City of Portland, Maine - Building or Use Permit Application

Permit No: 10-0457	Issue Date:	CBL: 028 K002001
------------------------------	--------------------	----------------------------

Location of Construction: 66 PEARL ST (151 Middle)	Owner Name: LEADER PROPERTIES LLC	Owner Address: 100 COMMERCIAL ST	Phone:
Business Name:	Contractor Name: Carrot Signs	Contractor Address: 236 Meadow Cross Road Topsham	Phone 2077250769
Lessee/Buyer's Name	Phone:	Permit Type: Signs - Permanent	Zone:

Past Use: Commercial -Retail - Bull Moose	Proposed Use: Commercial -Retail - Bull Moose - install a 4' x 4' hanging sign	Permit Fee: \$97.00	Cost of Work: \$97.00	CEO District: 1
Proposed Project Description: install a 4' x 4' hanging sign		FIRE DEPT: <input type="checkbox"/> Approved <input type="checkbox"/> Denied	INSPECTION: Use Group: Type:	
		Signature:	Signature:	
PEDESTRIAN ACTIVITIES DISTRICT (P.A.D.)				
Action: <input type="checkbox"/> Approved <input type="checkbox"/> Approved w/Conditions <input type="checkbox"/> Denied				
		Signature:	Date:

Proposed sign location (to the right of Videoport's sign)

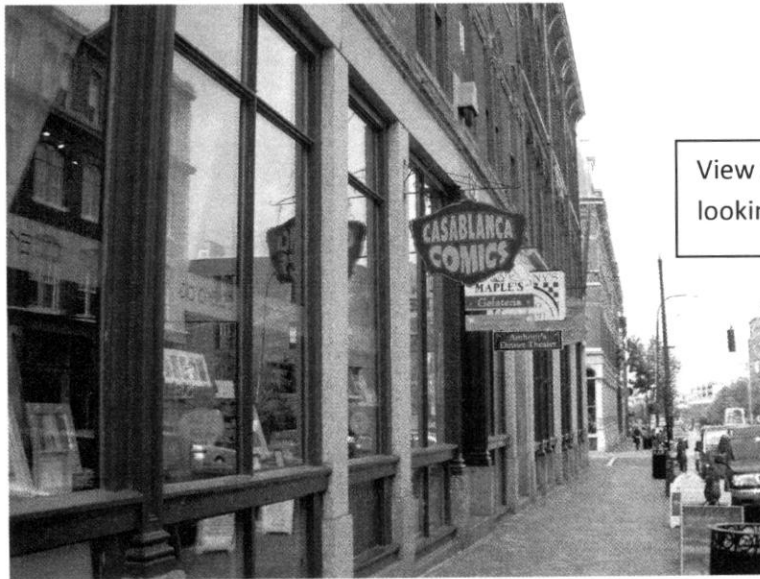
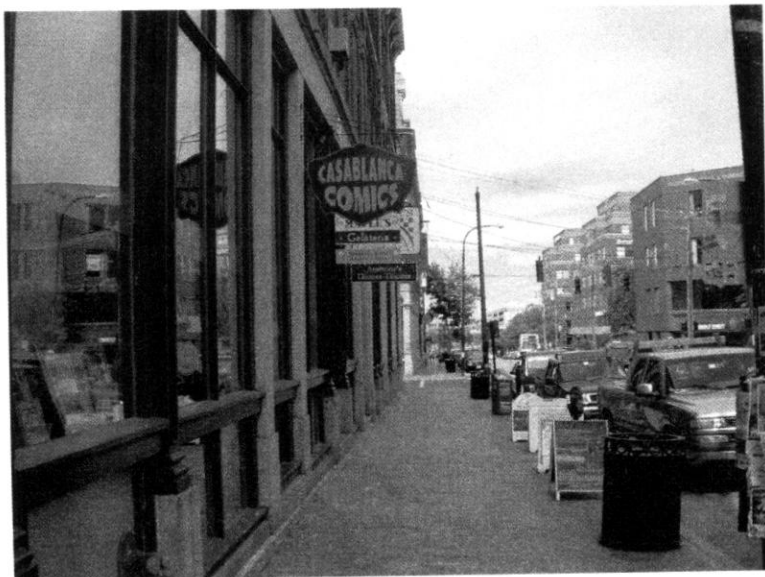
1) * Sign bracket to be hung at same height as those for other signs on building.

* Any sign lighting must be incorporated into sign bracket and be painted black. No exposed conduit allowed.

1) ANY exterior work requires a separate review and approval thru Historic Preservation. This property is located within an Historic District.

1) Signage Installation to comply with Chapters 31 & 32 of the IBC 2003 building code.
